***One Central Park (Block 2), 26 Broadway,  
Chippendale (former Carlton United Brewery site)***

***MP 09\_0078 MOD – 1 Modification to Approved  
Building Layout***

Director-General's Environmental Assessment Report  
Section 75W of the  
*Environmental Planning and Assessment Act 1979*

March 2011

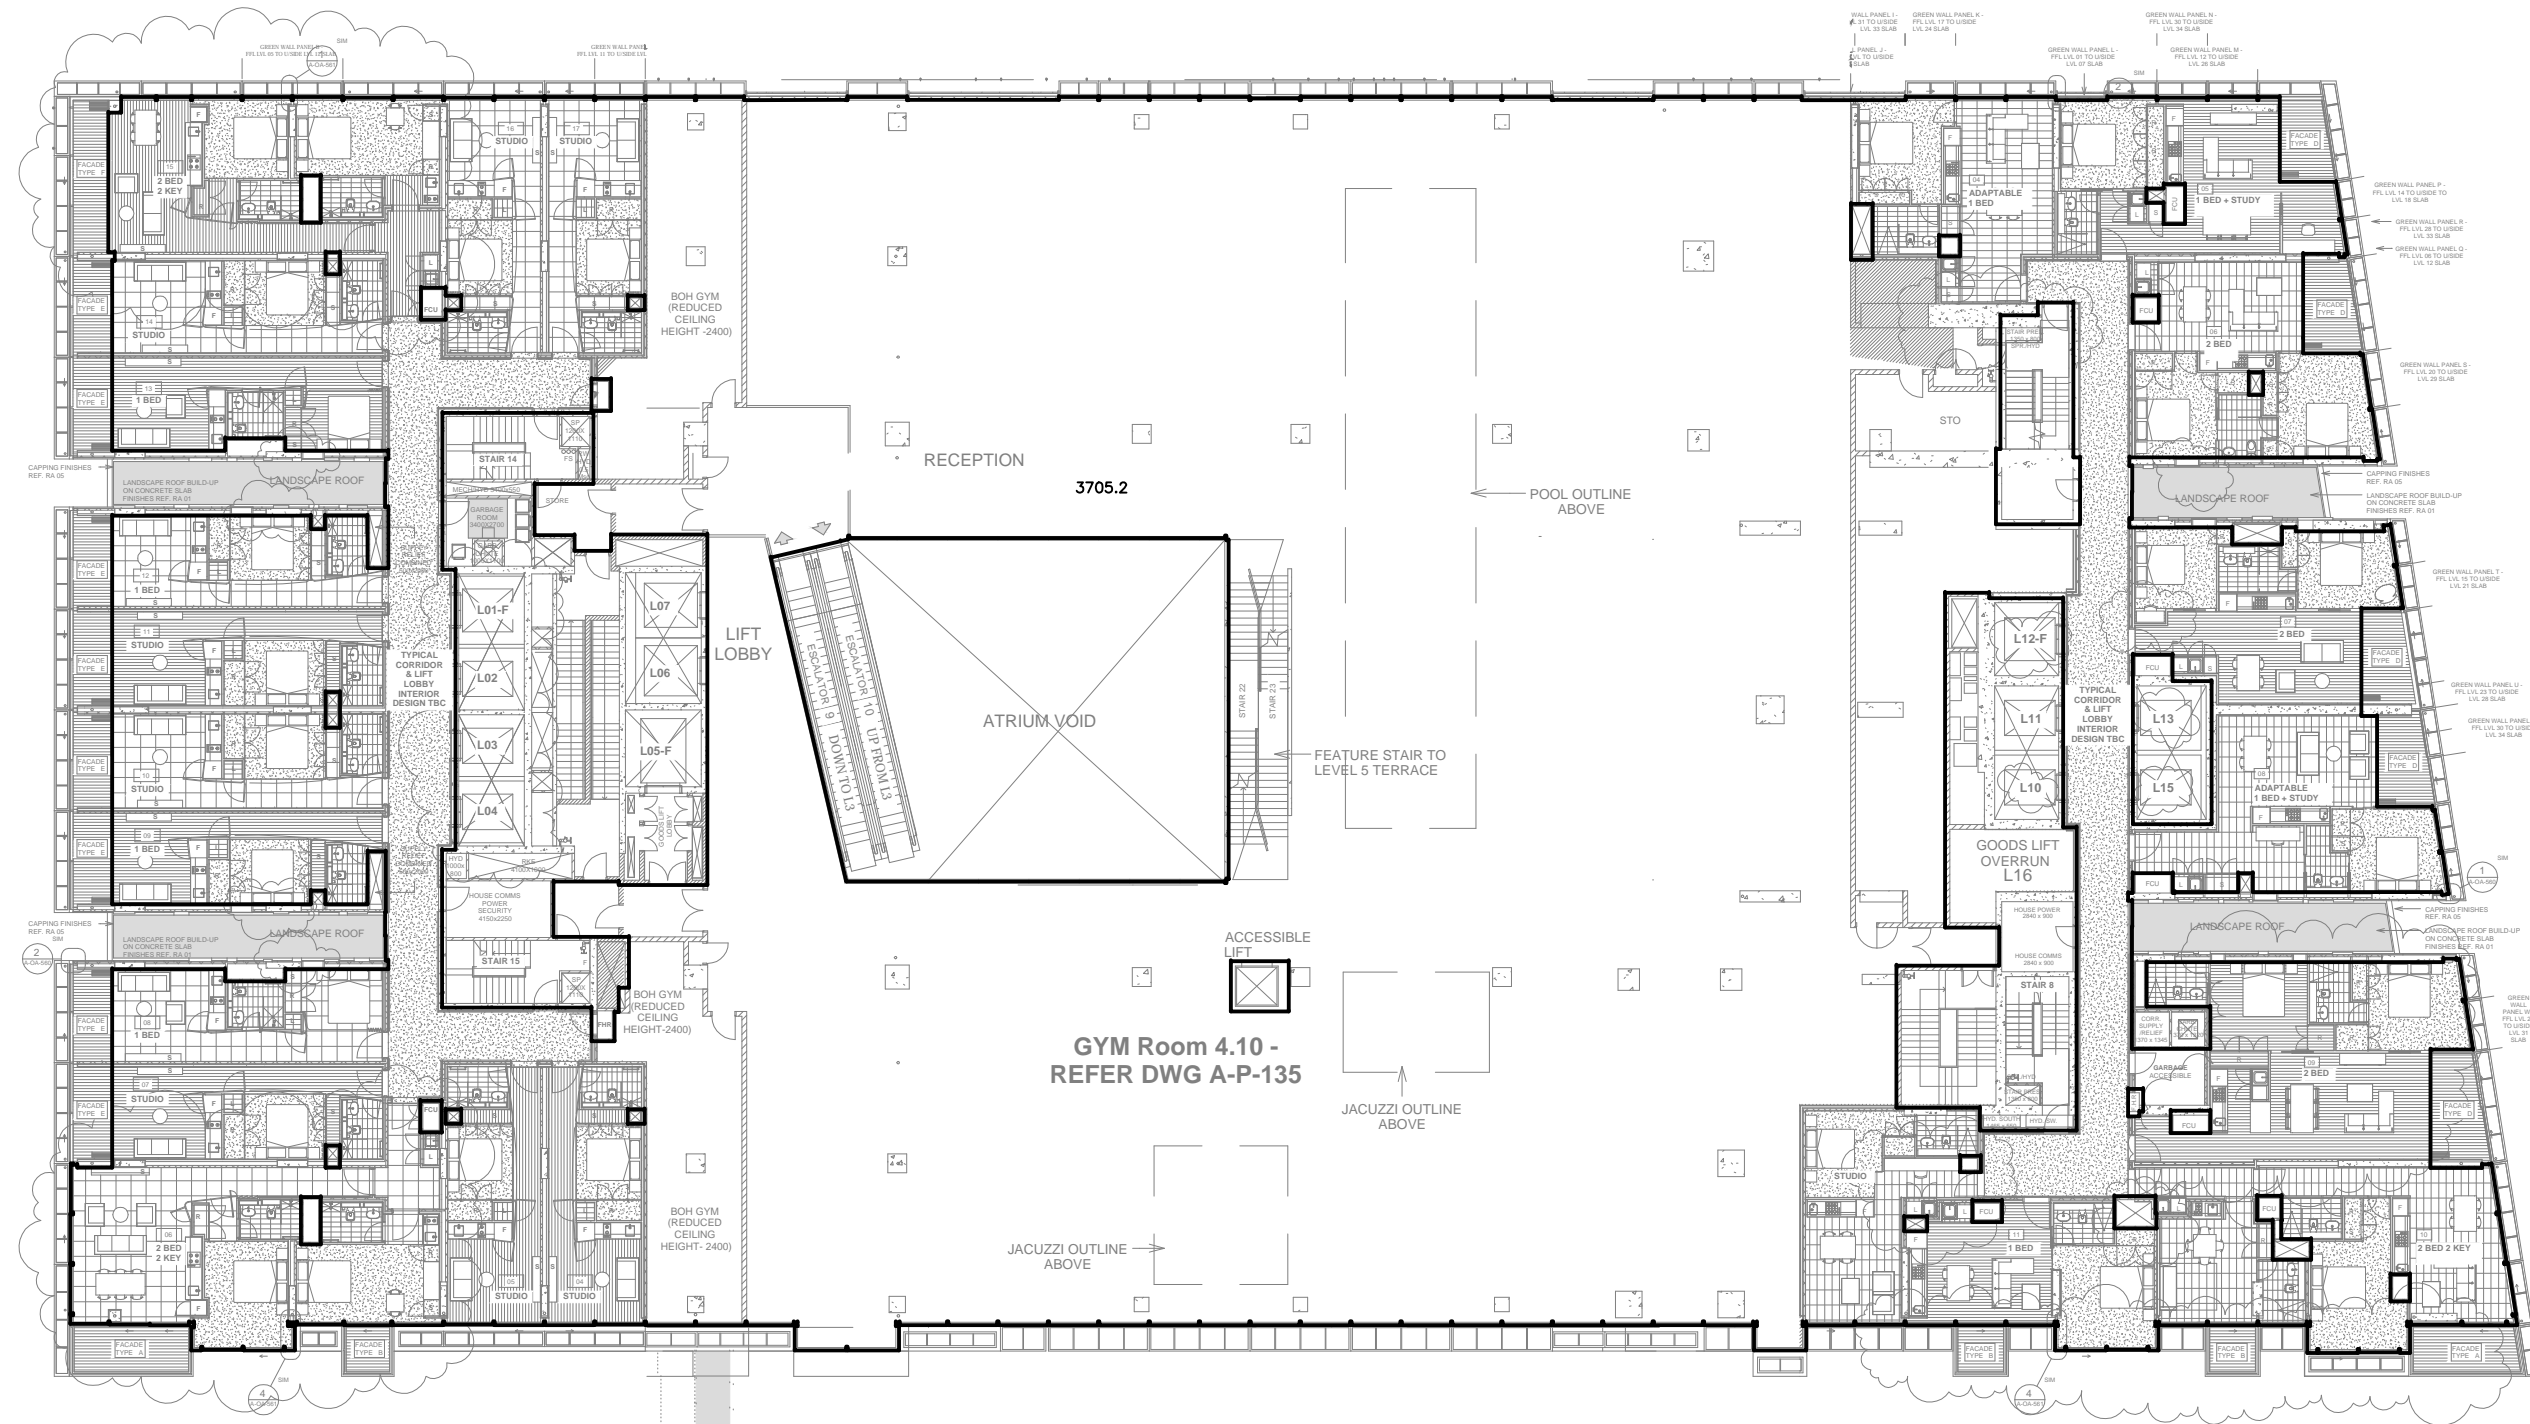
- Apartment 12 provided on Level 4 receives no cross flow ventilation, less than 2 hours of sunlight access and does not include an area of outdoor open space. A view is provided to the south towards Block 5A/5B.

- Apartment 04 and 05 provided on Level 4 receives no cross flow ventilation, less than 2 hours of sunlight access and does not include an area of outdoor open space. A view is provided to the south over the landscape platforms towards the Main Park.

To improve the amenity of this apartment, it is considered that a balcony be provided off the living area to provide an area of outdoor open space.

To improve the amenity of this apartment, it is considered that a balcony be provided off the living area to provide an area of outdoor open space.

WEST TOWER
LEVELS 6, 9 & 15,
GFA = 1209.1m²

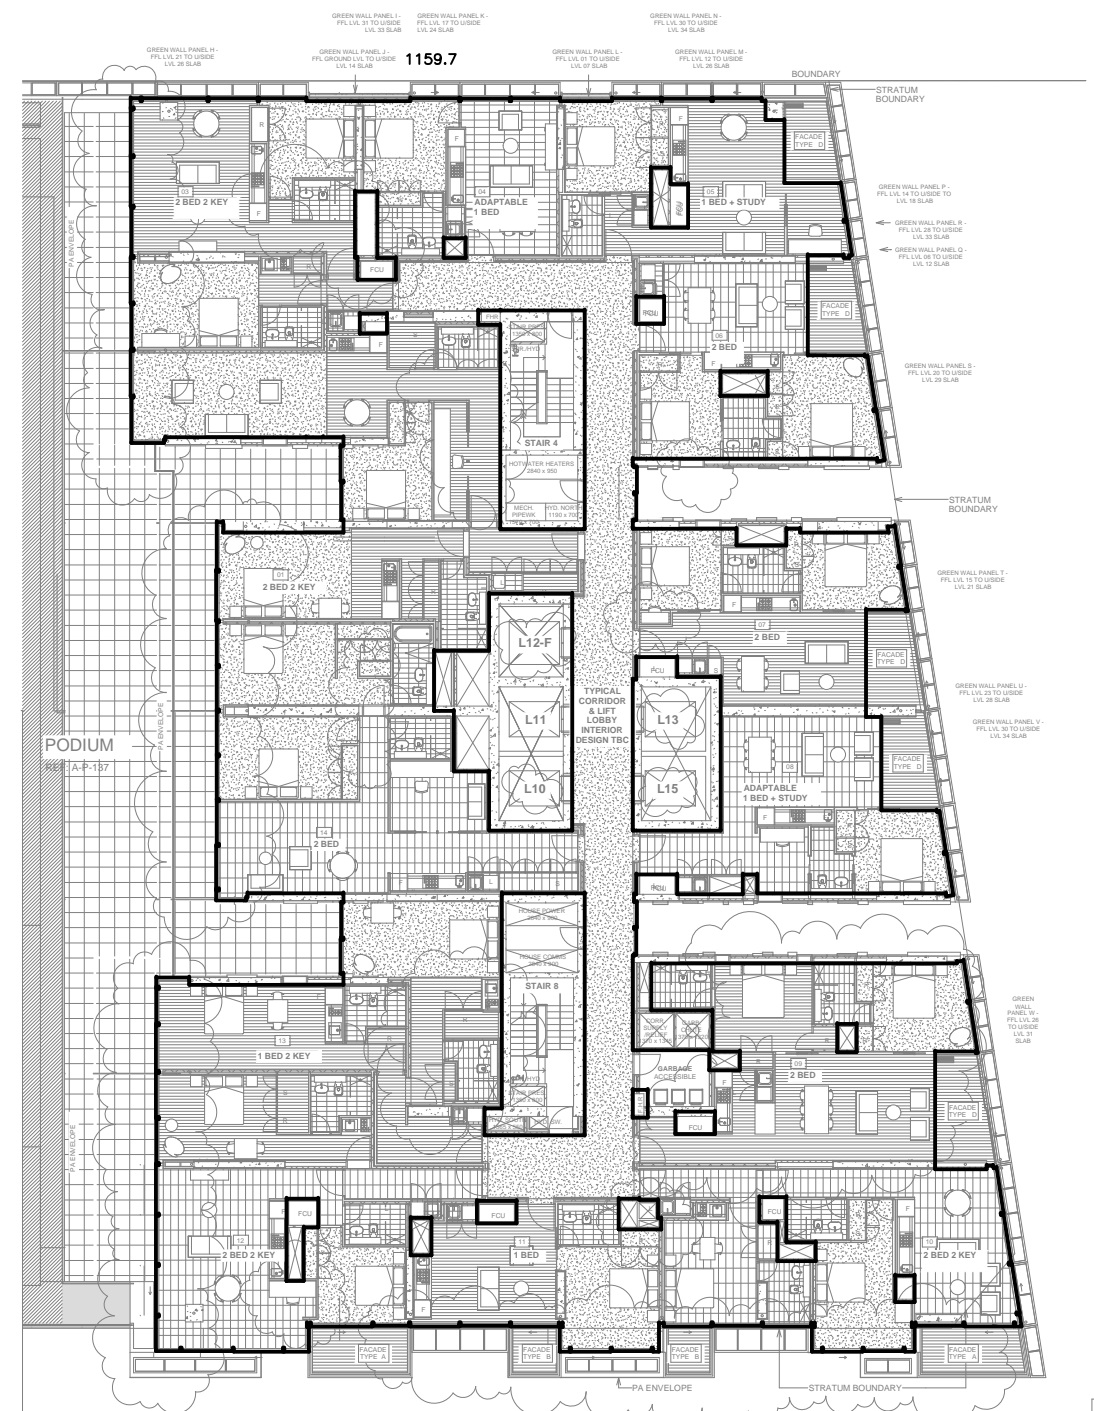
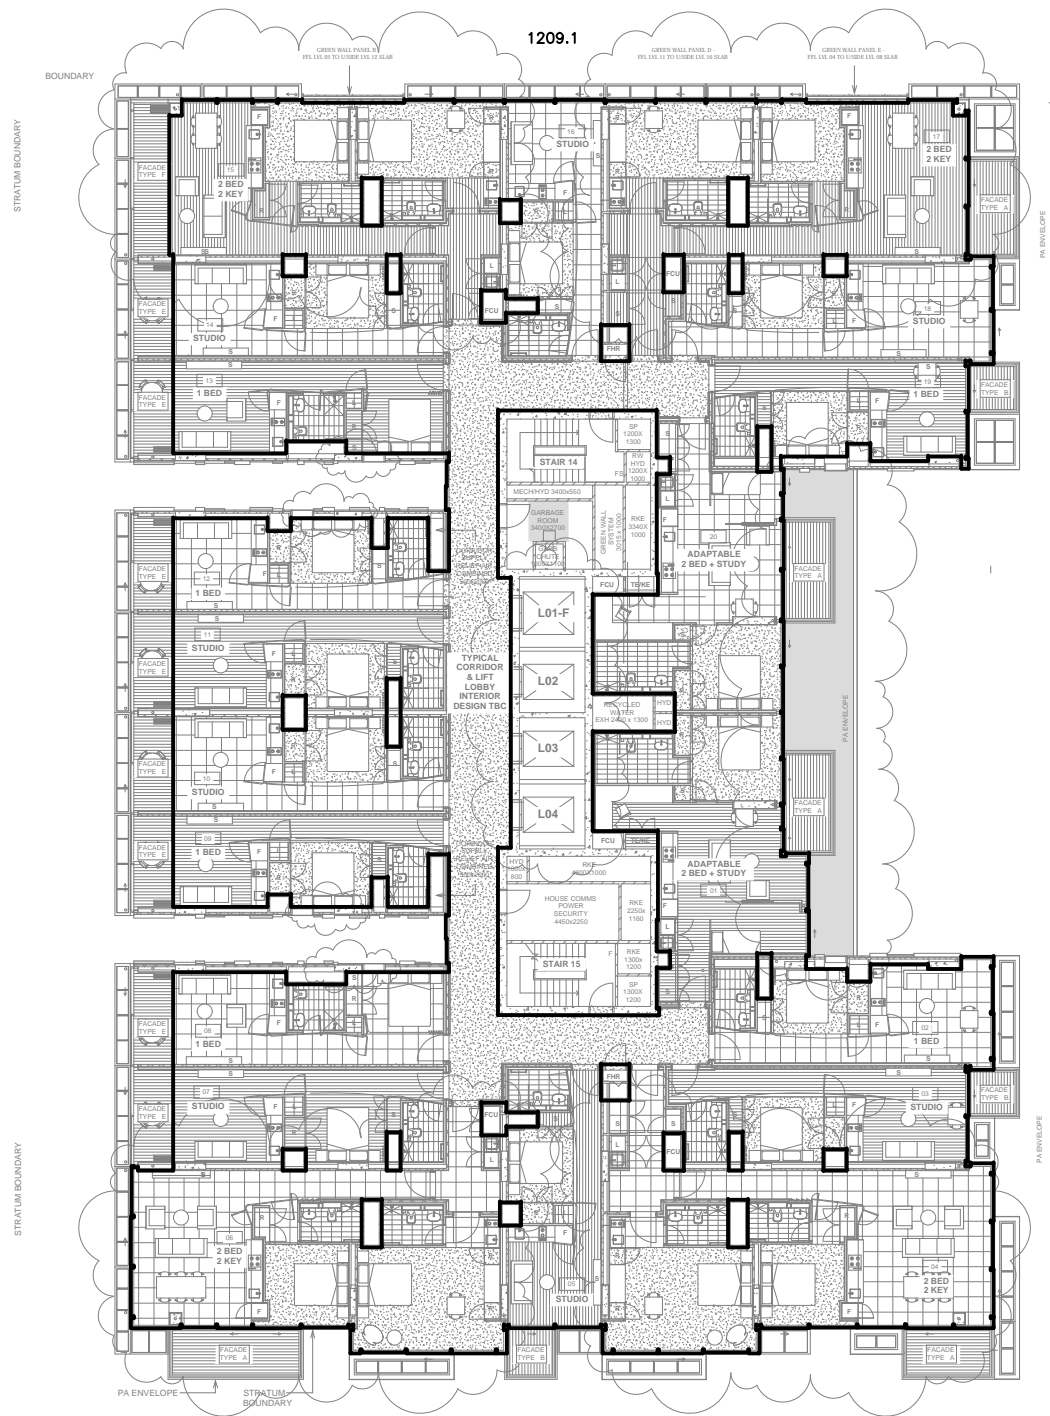
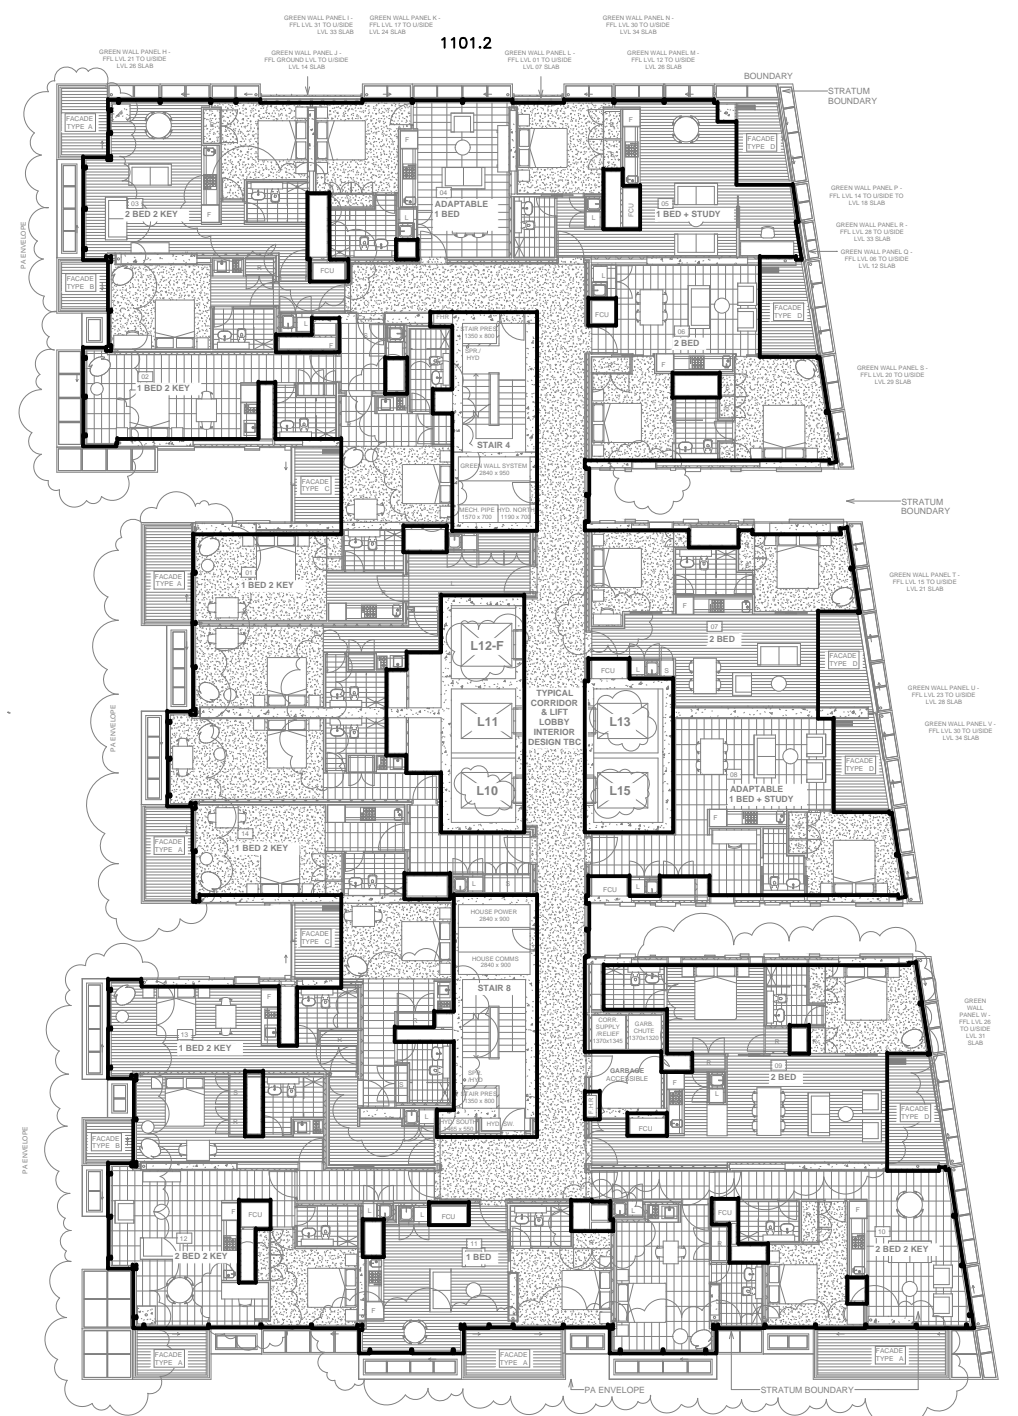
- East Tower
  - Apartment 12 on Level 5, 6, 9 and 12 (smaller apartment of the 2 bed 2 key apartment is provided with an area of 28.7m<sup>2</sup> including half of the common area) receives no cross flow ventilation and less than 2 hours of sunlight access. The apartment is provided with an area of outdoor open space over the common area between the two

towers. Despite this outdoor open space area, the amenity of the apartment is reduced due to the above issues.

In order to improve the amenity of the apartment, it is recommended that the apartment be amended and replaced with a 2 bedroom apartment (not 2 key).
